### ***Headland Park and Northern Cove – Main Works (MP 10\_0048 MOD 3)***

Director-General's  
Environmental Assessment Report  
Section 75W of the  
*Environmental Planning and Assessment Act 1979*

April 2013

BARANGAROO HEADLAND PARK - UPDATED (S75W) SITE PLAN

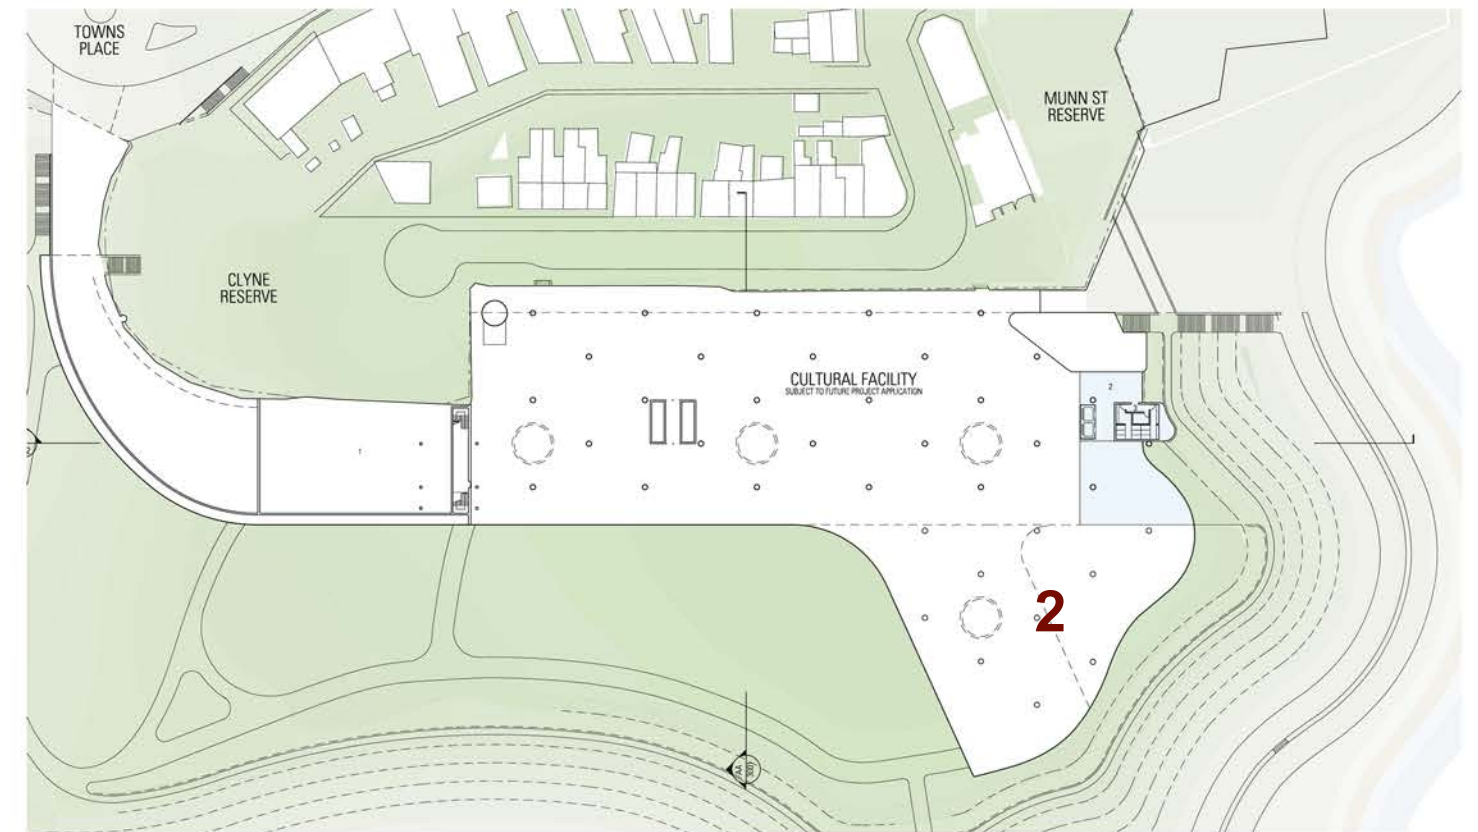
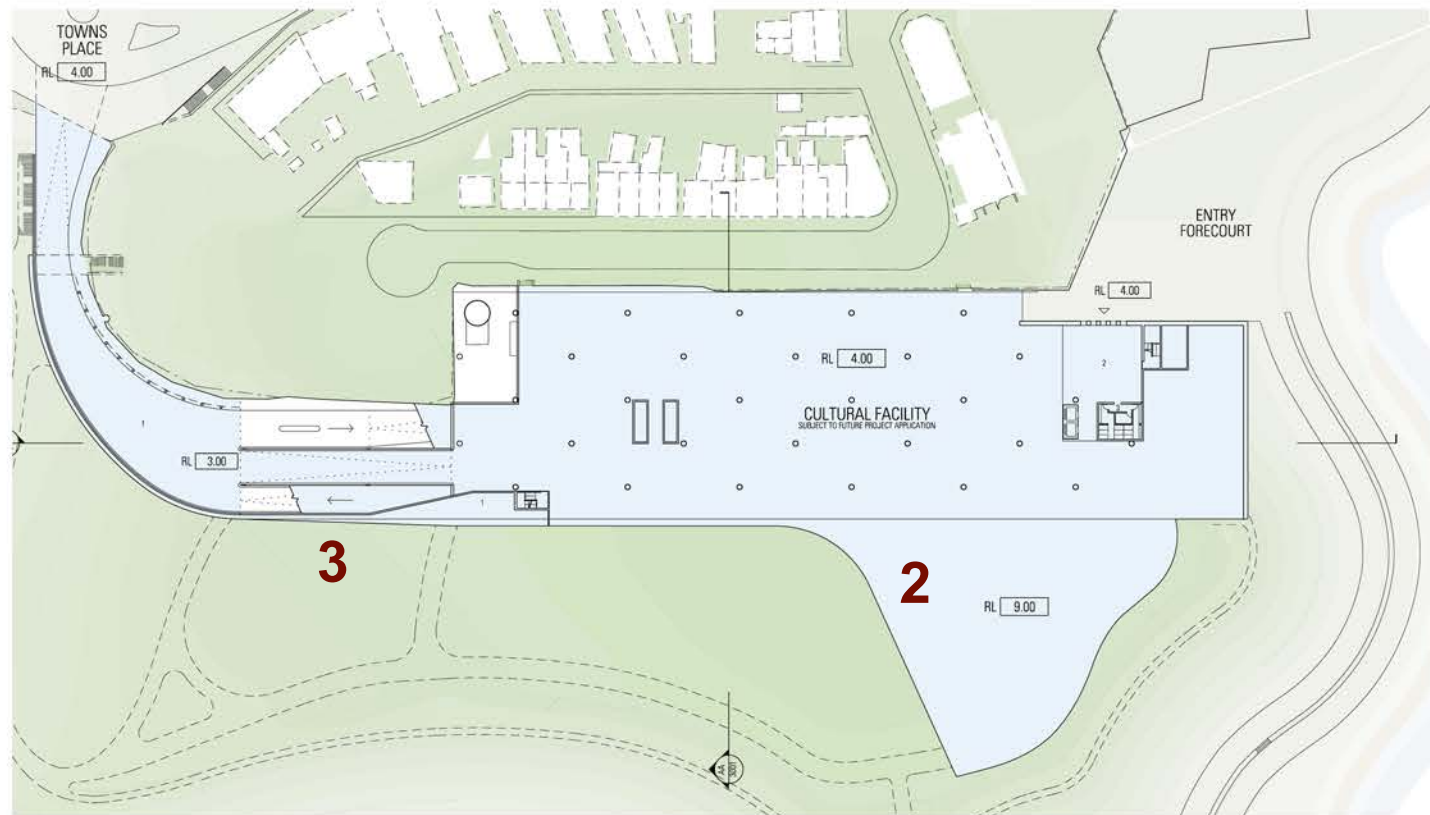
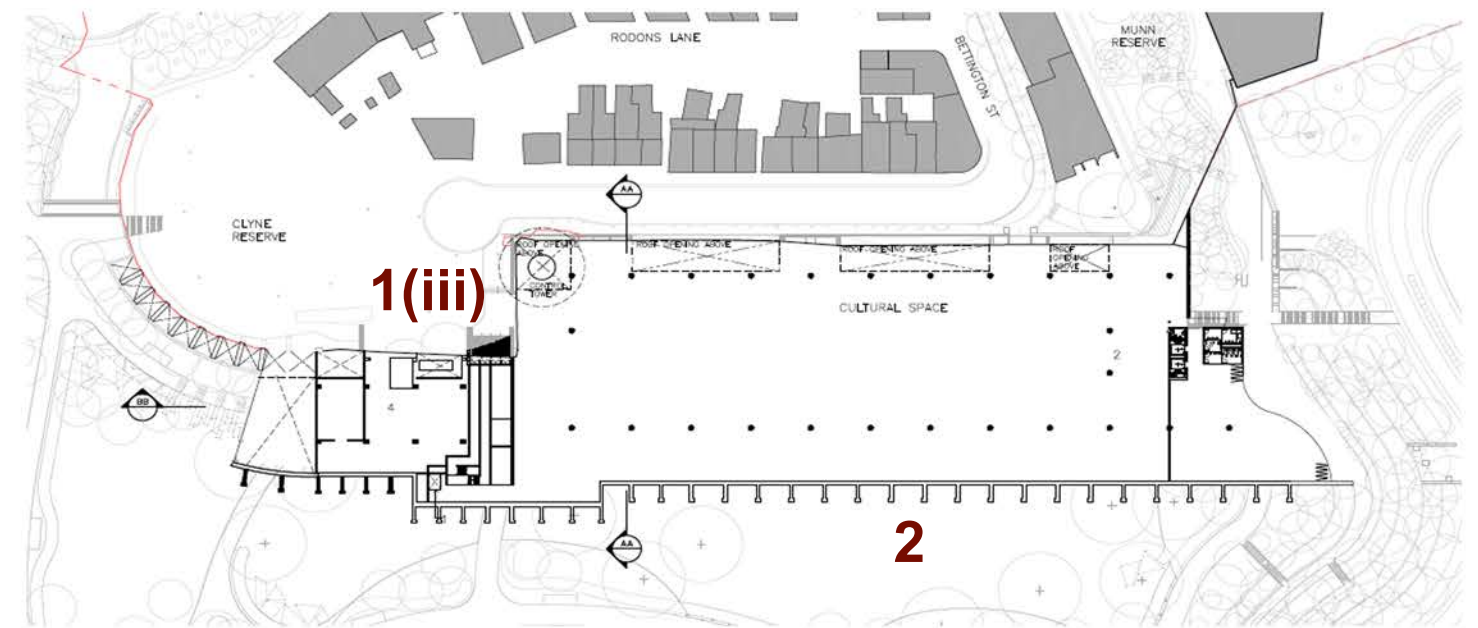
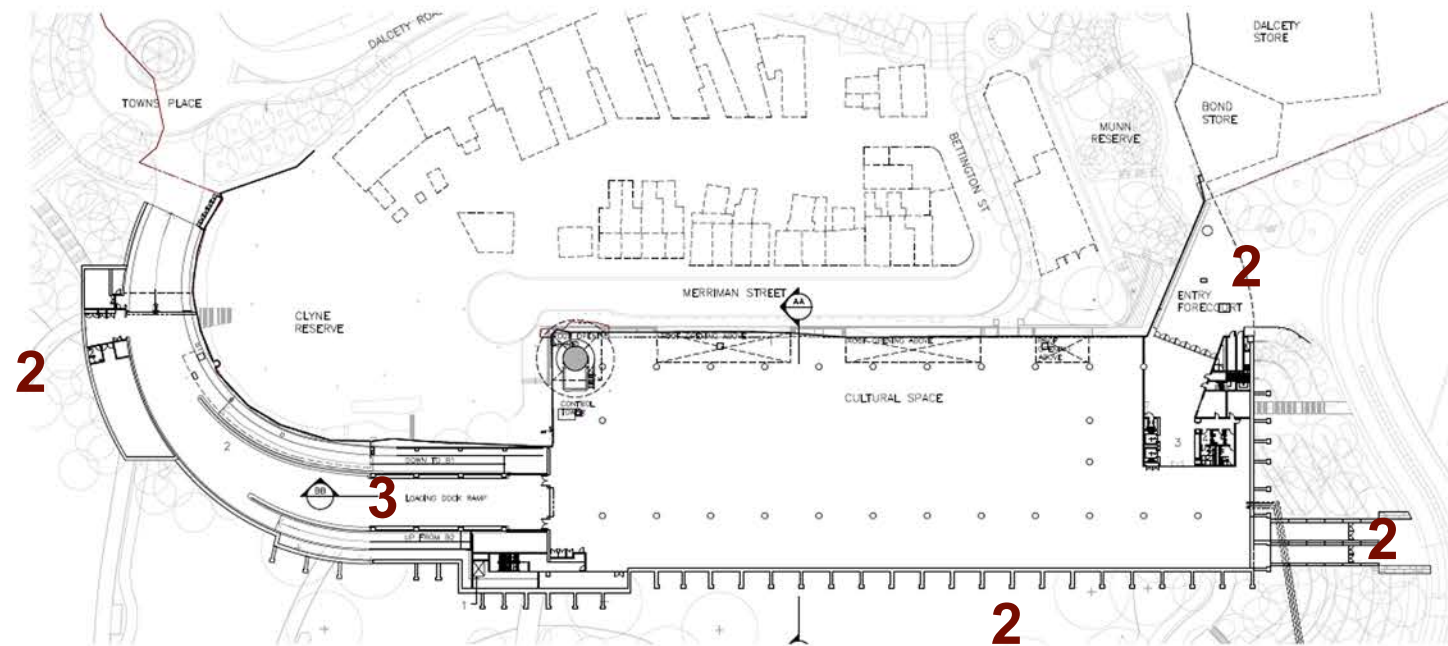
- The application proposes a significant change to the cultural facility envelope at RL 4.0 and RL 13. This change would require additional fill and would have a major impact on the physical potential and flexibility of the space for future cultural uses. The EA does not address these impacts;

- The proposed modification would result in the creation of a foyer area that is in perpetual shade, making the principal entrance to the future cultural facility uninviting. The EA does not adequately address these impacts;

- The EA does not include ground level views of the re-designed entry to the cultural facility, and no assessment of its impact on the public domain at the harbour foreshore level. In order to maintain the design excellence of the harbour foreshore approach to the cultural facility, the approved design of the southern entrance should be retained;

- The proposed emergency egress from the cultural facility is unlikely to comply with the requirements of the BCA due to its proximity to large canopy trees on the southern bluff. Furthermore, if the trees are removed to ensure compliance with the BCA, the proposed fire egress stairs would be highly visible from the harbour side of the Headland Park and may detract from the landscape design of the Headland Park and the architectural design of the cultural facility. The proponent should provide a photomontage of the stairs when viewed from the public domain on the southern side of the Northern Cove to demonstrate whether the impact of the stairs would be acceptable; and

- The application does not represent a significant change to the envelope of the approved cultural facility. The original Environmental Assessment (EA) sought approval for the creation of a future cultural space ranging in size between 70,000 m<sup>3</sup> and 100,000 m<sup>3</sup>. Furthermore, the application sought approval for the placement of up to 350,000 m<sup>3</sup> of fill plus topsoil on site. The application does not represent a departure from the concepts approved under the main works project application given that the final volume of the future cultural space will be approximately 80,000 m<sup>3</sup>, and will require the placement of approximately 240,000 m<sup>3</sup> of fill;

- The long-span structural solution at the south-eastern entrance of the future cultural facility allows for maximum flexibility in the design of the future facility without disrupting the integration of the underground space with the naturalistic form of the park. There is potential for the cultural space entry doors to be relocated in the future to provide a new entrance statement under the edge of the land bridge;

- The fire egress at the south-eastern corner of the future cultural facility has been integrated into the surrounding landscape. In particular the impact of the fire egress on the foreshore has been minimised by keeping the ceiling height of the egress below the first level of 'bush' retaining terraces thus reducing the break in the continuity of the terracing when viewed from the southern side of the northern cove;

- The BDA's BCA consultant, Fire Engineer and Certifier have reviewed the proposed fire egress at the south-eastern corner of the future cultural facility and have concluded that the required width for egress (7.0 m unimpeded) can be achieved. Therefore the proposed egress is compliant with the requirements of the BCA; and

- The proposed fire stairs adjacent to the entry of the future cultural facility have been oriented to minimise their visual impact when viewed from the foreshore promenade. Given that there is no alternate location for the fire stairs the department is satisfied that the proposed stairs are appropriate.

BARANGAROO HEADLAND PARK - CARPARK COMPARISON

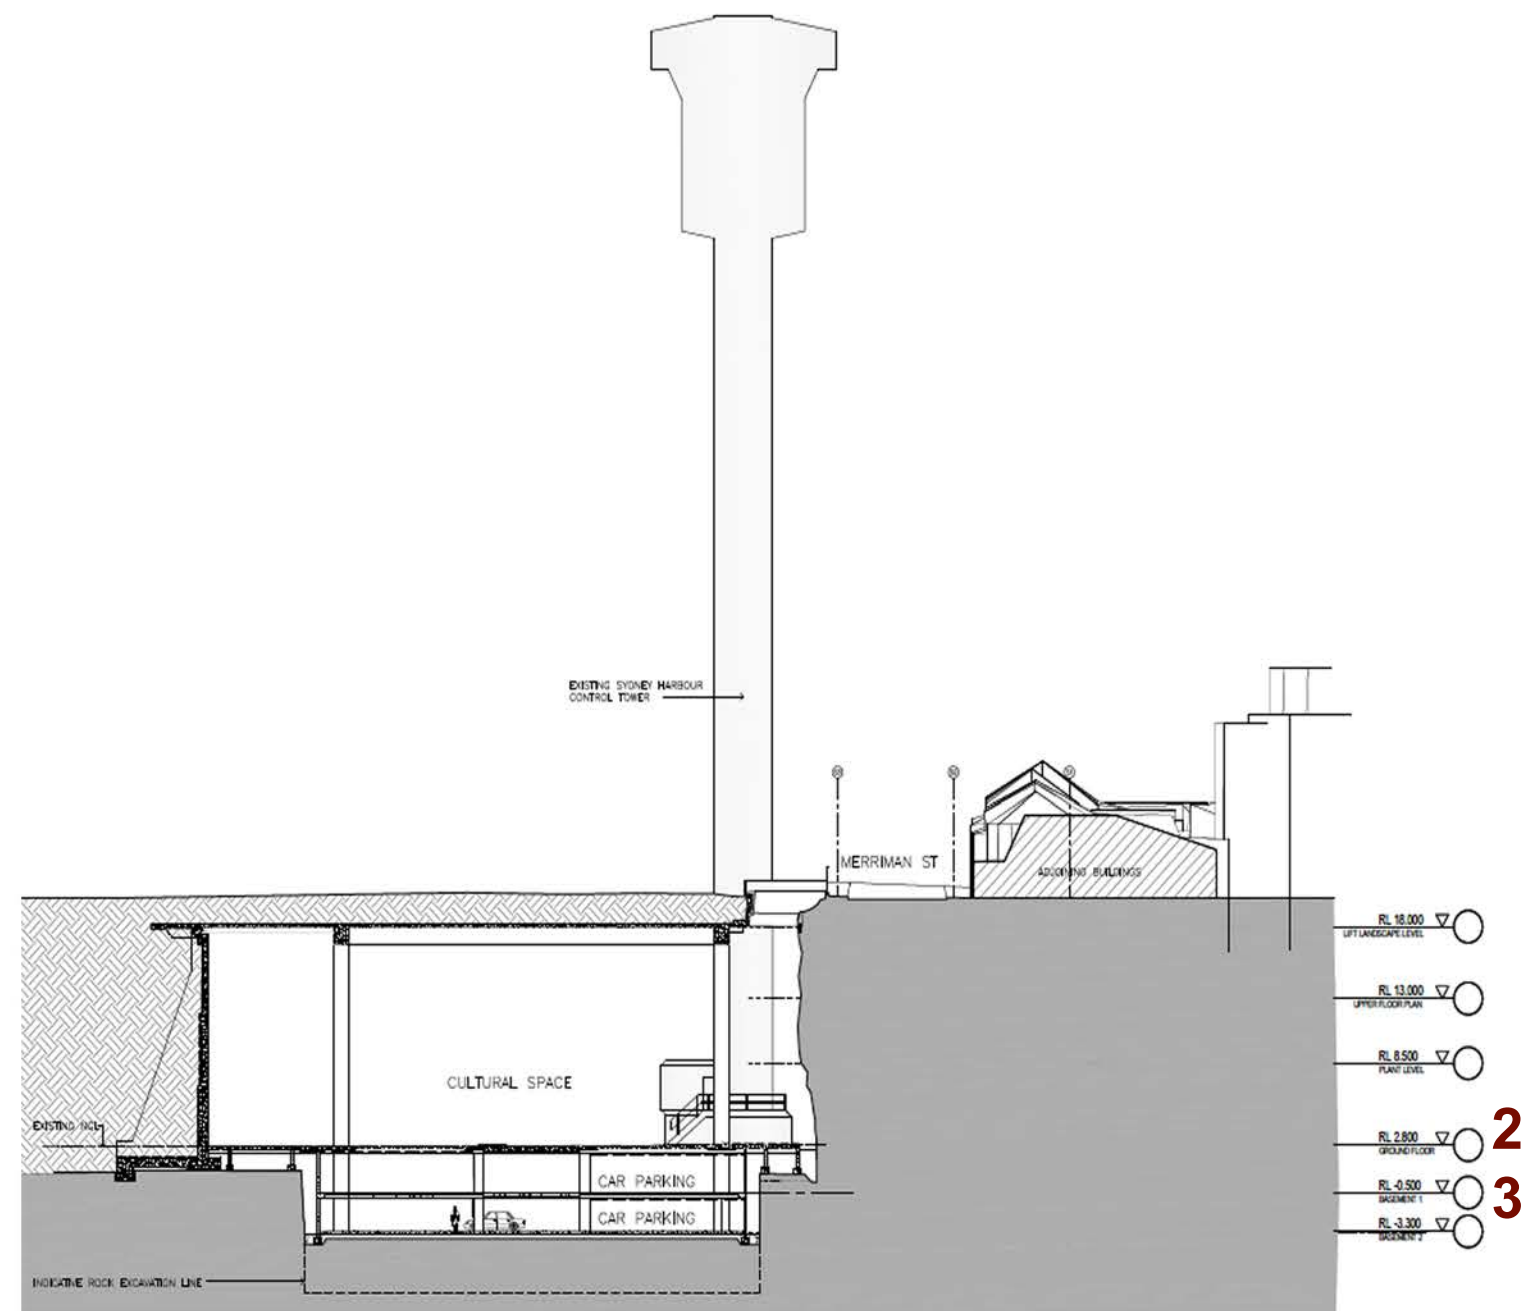
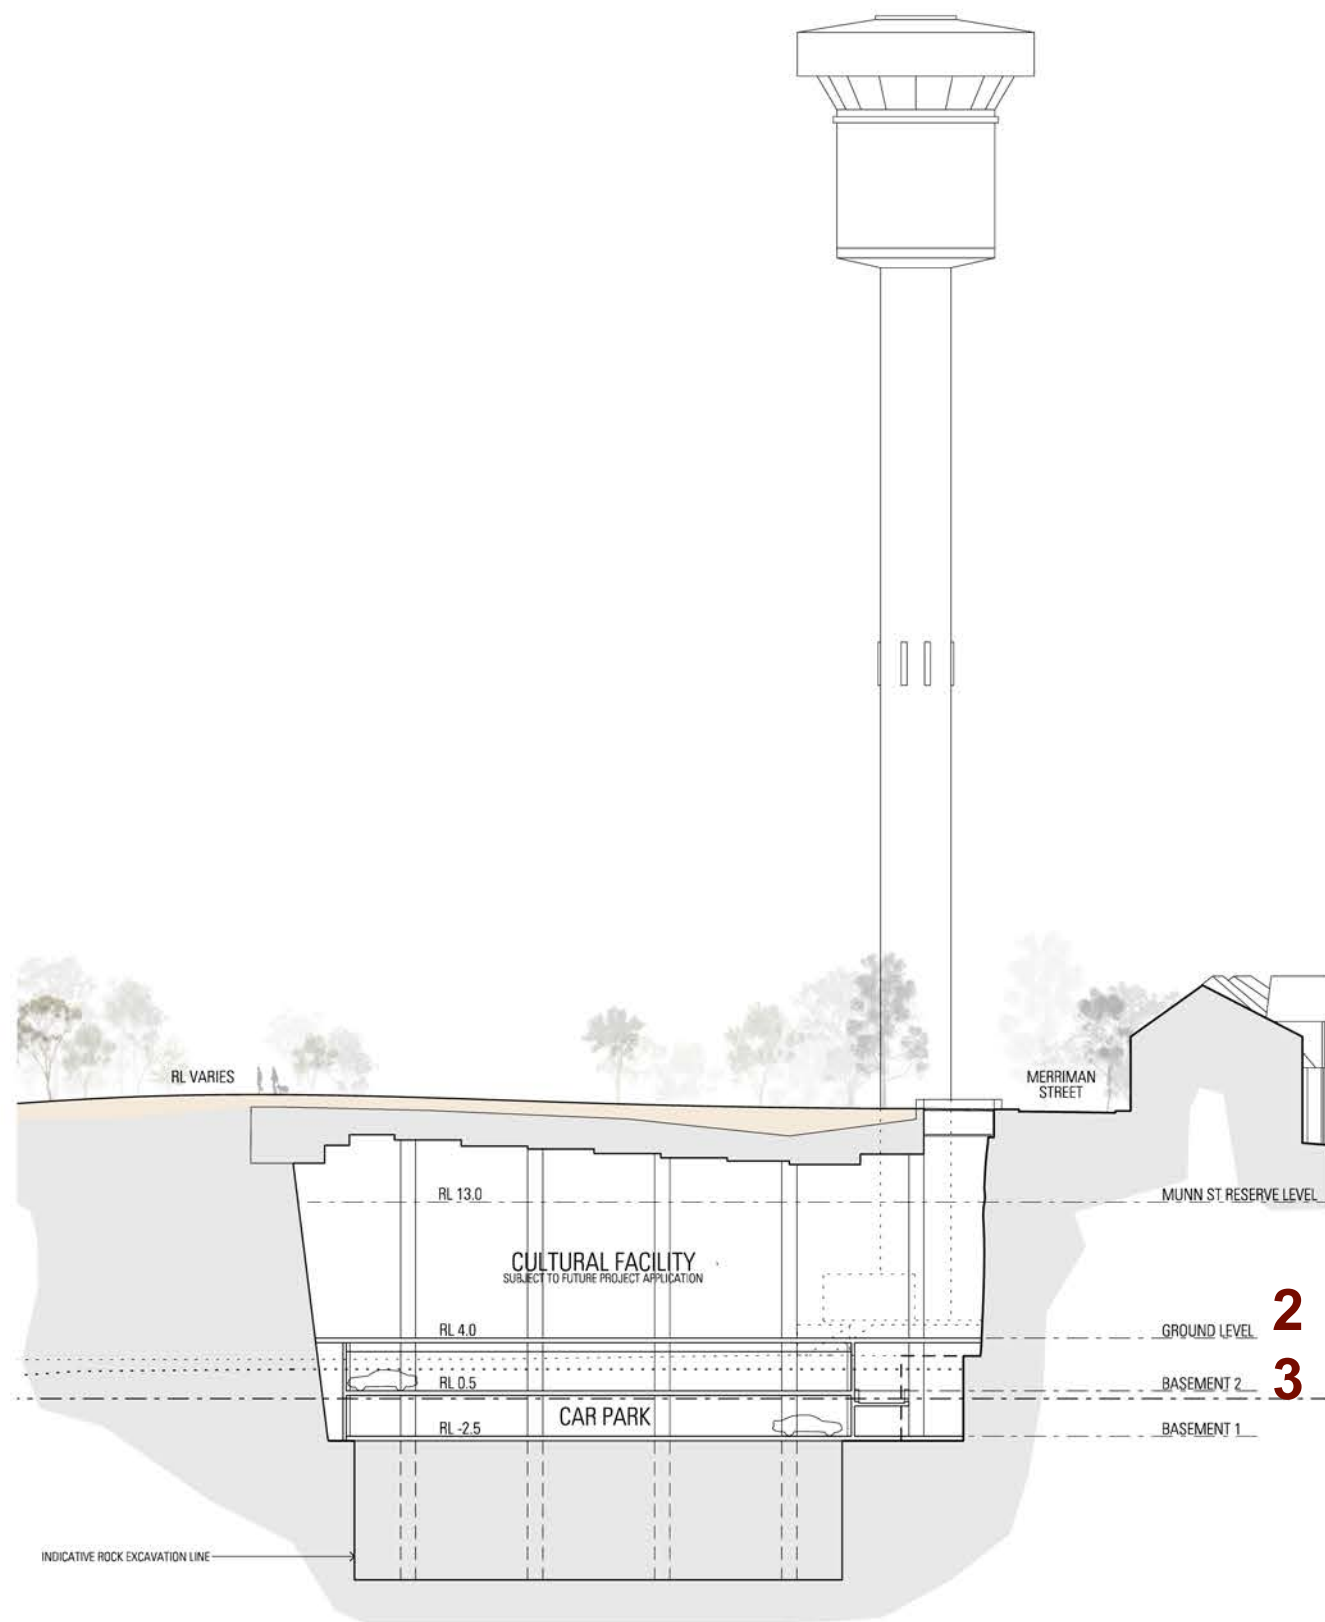
- The approval of a hotel over the water is opposed [note: this is not relevant to this application];
- The original roof profile of the car park and cultural facility stepped north-south and east-west with tree pits to support major trees and sub-surface drainage. Replacement of this roof form with a 'Super T' pier and beam structure with no east-west fall may compromise the 'roof garden' concept approved under the original project as the revised design may cause on-going structural issues such as ponding, and may preclude the growth of healthy and stable trees;

- The western edge of the retaining wall of the basement car park which is currently under construction appears to be inconsistent with the existing planning approval;

- The use of a 'Super T' pier and beam structure would not preclude the planting of significant trees in the area immediately above the future cultural facility. Furthermore, the depth of the soil above the cultural facility roof is consistent with the soil depths recommended in the report entitled *Barangaroo Headland Park Concepts in Soil Landscape Reconstruction November 2010*, prepared by Simon Leake (project soil scientist) and Stuart Pittendrigh (project horticulturalist);

- Waterproofing and drainage issues were considered and resolved by the BDA's technical experts prior to the lodgement of the proposed modification. In this regard, the grinders will be topped

with an in-situ roof slab overlain by a waterproofing membrane, drainage layer and thermal insulation layer;

- The proposed roof design will provide a superior drainage outcome as sub-soil drainage will be achieved via the creation of a convex shaped roof structure, which would reduce potential on-going maintenance and waterproofing issues associated with the creation of vessel shapes in the roof. Furthermore, it will provide for improved tree health as root growth will not be restricted by tree pits;

- The construction contractor (Balderstone) has confirmed that the current works are consistent with the 109R Certificate issued by the project certifier (Phillip Chun) on 17 October 2012;

**Figure 4** below). Furthermore, the department accepts that the use of a concave roof form would provide an improved drainage solution and would assist healthy tree growth via the removal of the trench system which may restrict root growth;

- Based on a review of the drawings approved under the 109R Certificate, the department is satisfied that the retaining wall that is currently under construction is consistent with the project as it is currently approved (see **Figure 5**);
